File No: NTH09/01696

**Proposed Modification MP 09\_0166 MOD 3. Altitude Aspire Residential Subdivision. Terranora.**

Date: 26 April 2018

TERRANORA PRECINCT 1
EXTENT OF PARKES LANE-TOWNSEND
CRESCENT ROUNDABOUT WORKS

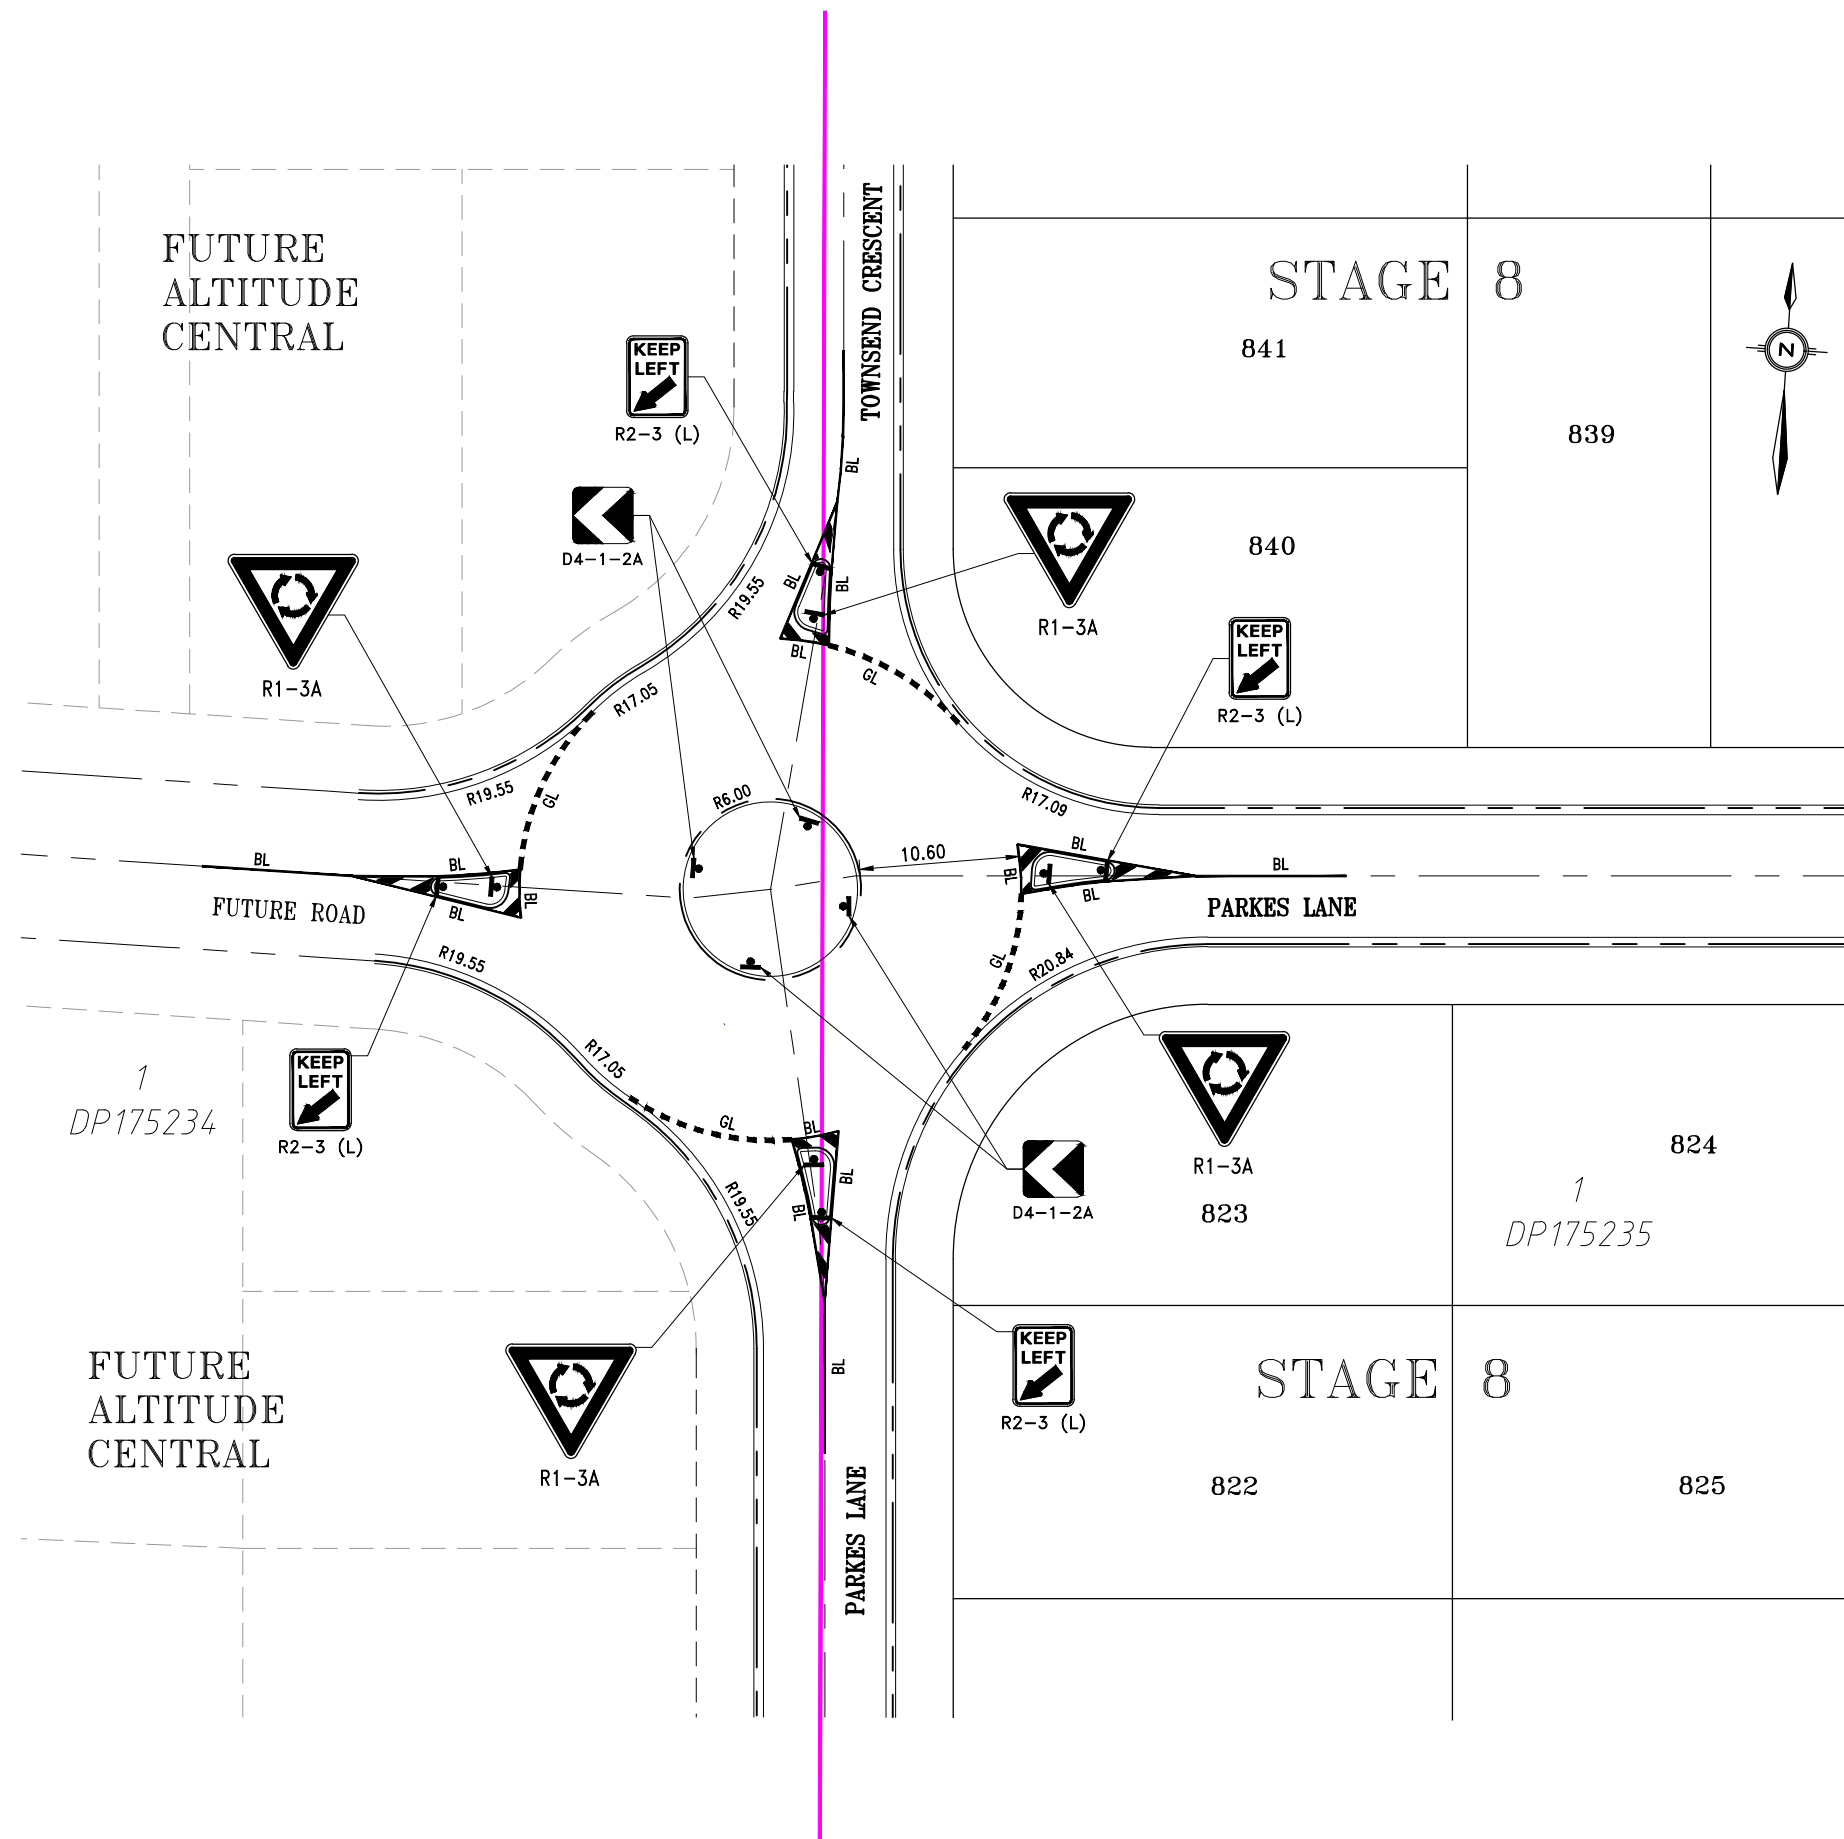
- Plans of the proposed roundabouts should be referred to Tweed Shire Council's Traffic Committee for consideration of the regulatory facilities.
